Please ask for: Ms Iqraa Malik
Email: iqraa.malik@terraquest.co.uk
Telephone: 01212341390
Our Ref: FP/123/21/HH
Your Ref:
Date: 26th May 2021

Application for Planning Permission for Works or Extension to a Dwelling

Development: Erection of two storey side extension and alteration to fenestration/openings
Location: 56 Downview Road Felpham PO22 8HH

PROPOSED BLOCK PLAN
Scale 1:500

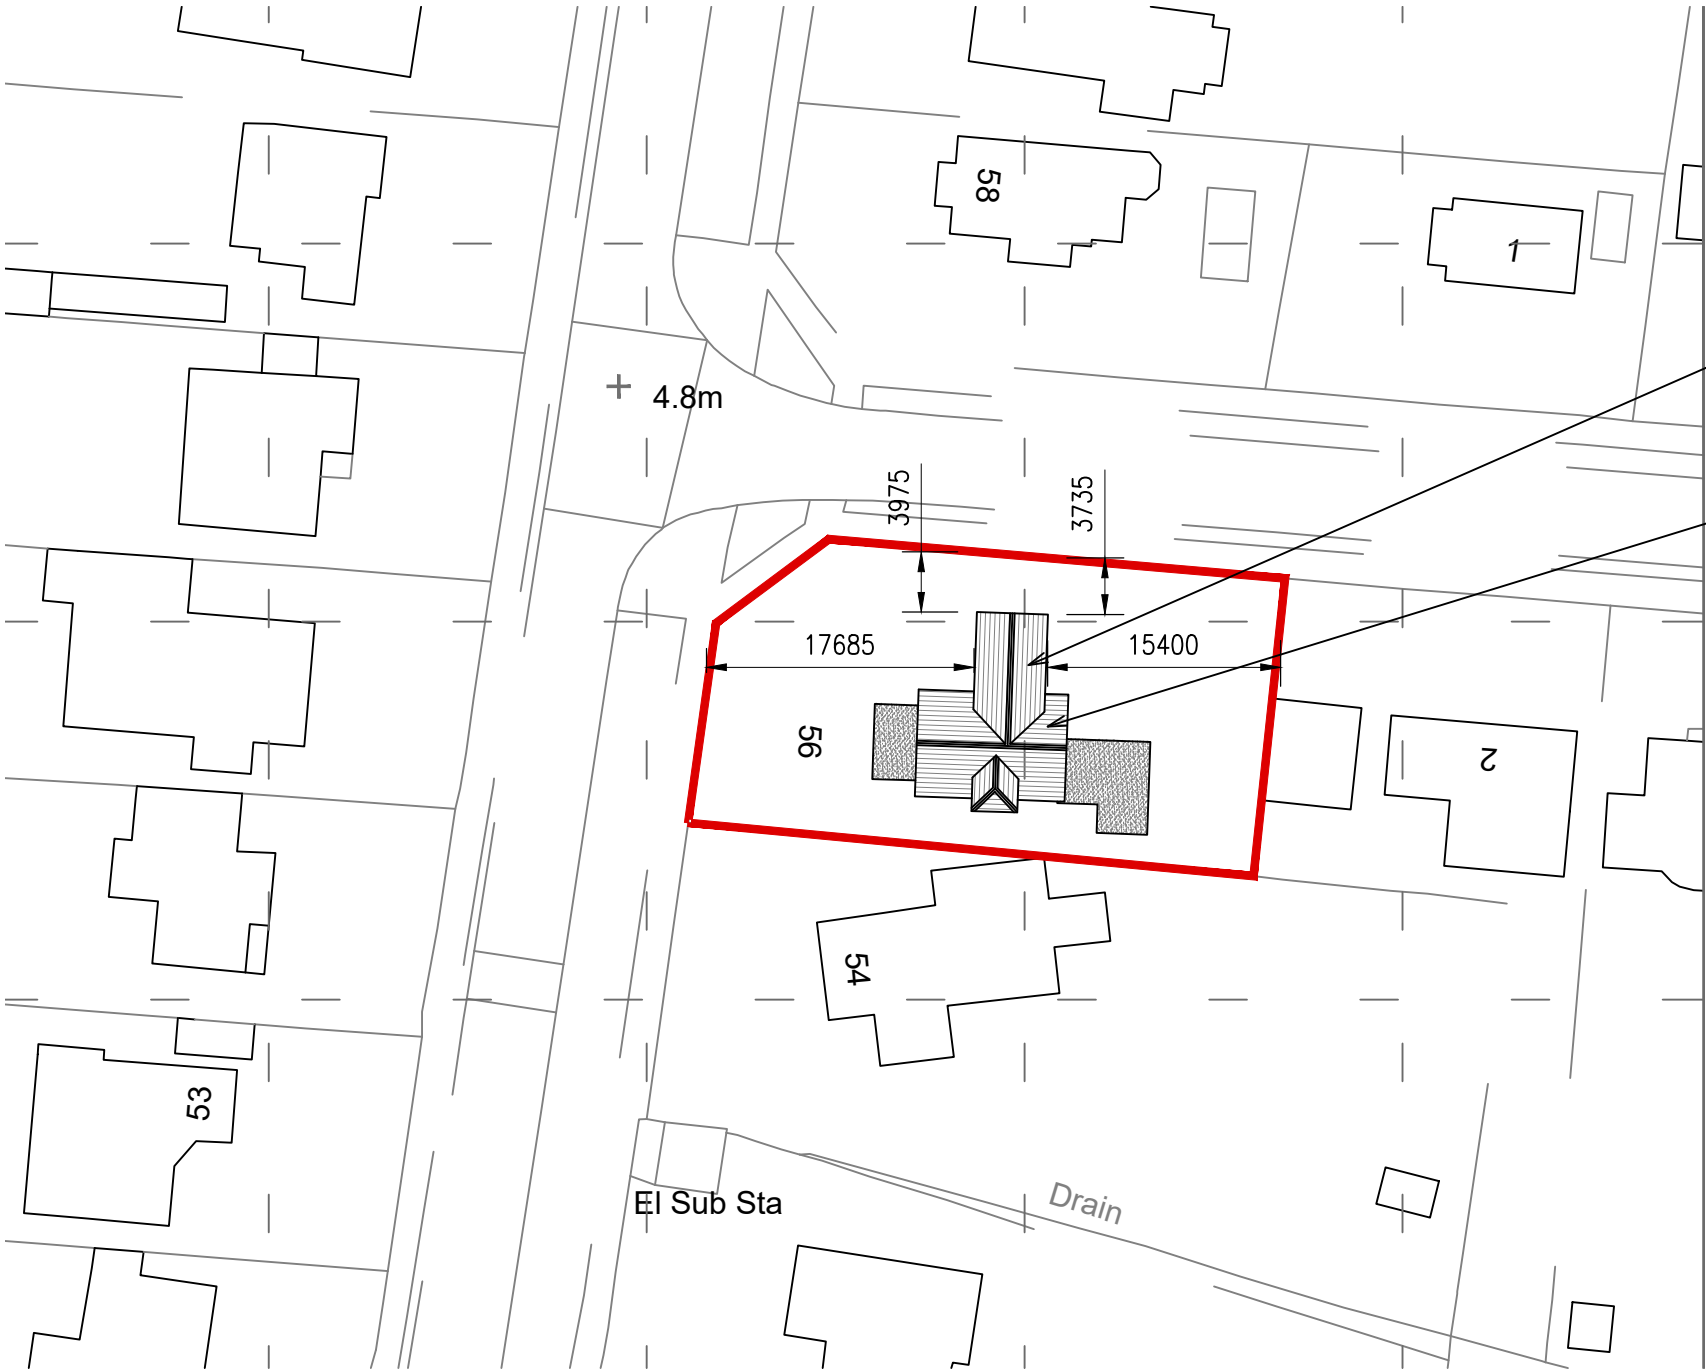
Block Plan

You are required to have dimensions from the proposed extension(s) to all site boundaries. Please amend
